Subject: Yapton SD7 Design Code Submission refs Y/40/20/DOC & Y/41/20/DOC

As I previously said, I think the Code is a vast improvement and certainly meets much of what he had asked for. However, we have the following comments and requested amendments:

Indicative illustrations of Village Street

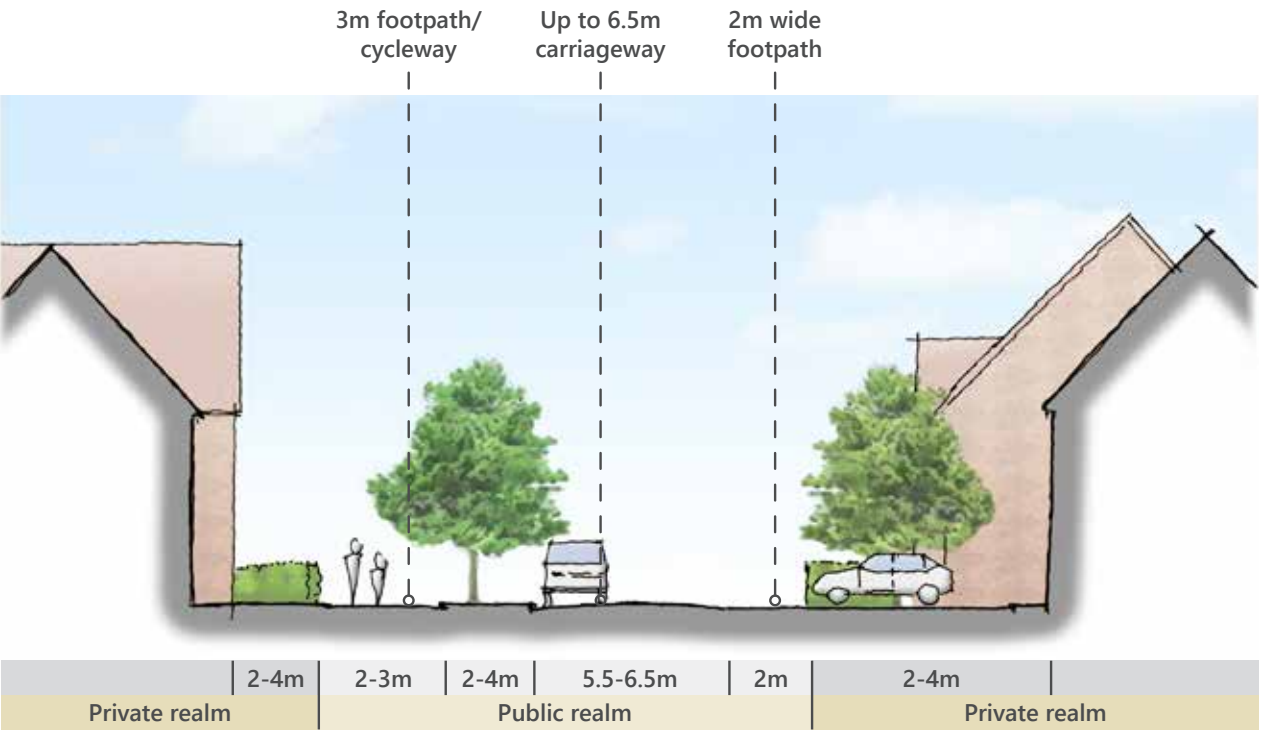
- (8) We don't consider frontage parking to be appropriate on the main village street.
- (9) The Code says that verges either side of the main village street will be 2m on both sides but 'as appropriate to setting'. This creates ambiguity. It would be better to add to this to clarify where verged will be wider or narrower whatever the case may be. It is also noted that the Outline D&A referred to 6-10m verges in these areas.

5.6 ACCESS AND MOVEMENT

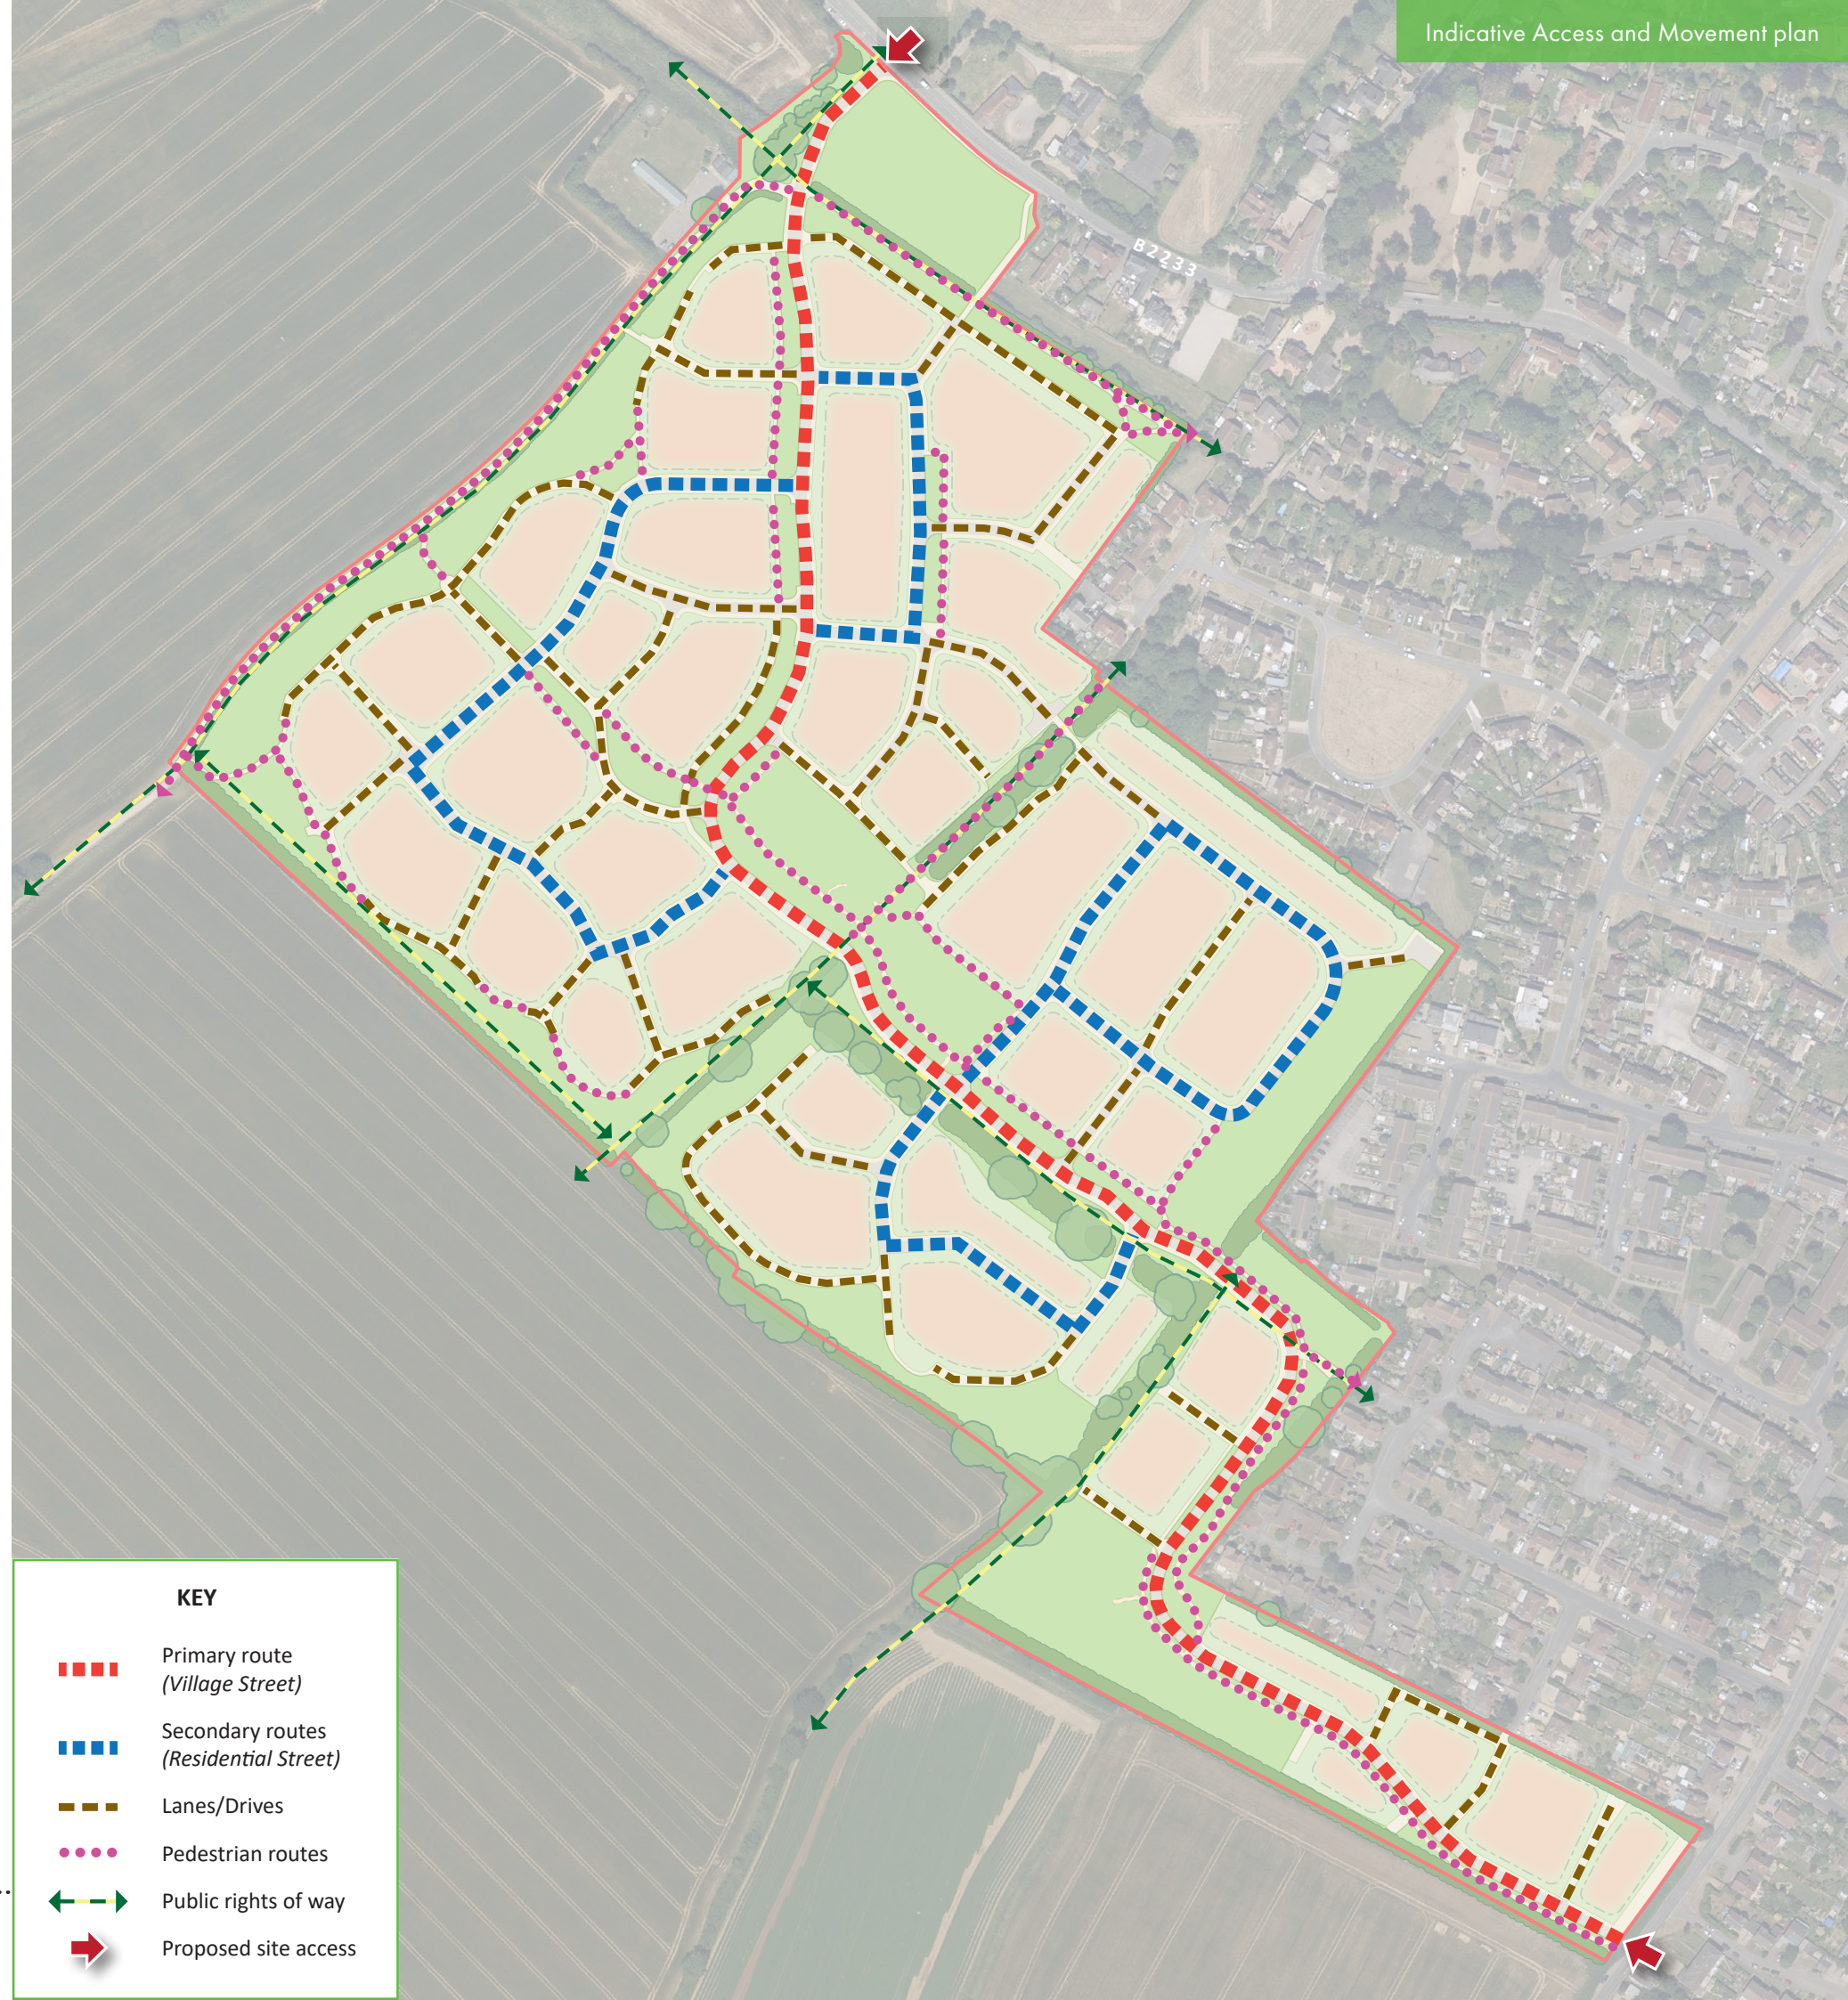
- (5) Also the cycleway route is not clearly shown on the plan on P.16. It does not make it clear that it is alongside the road and also not clear if there are more cycle routes. It might be worth having a separate cycle path plan.
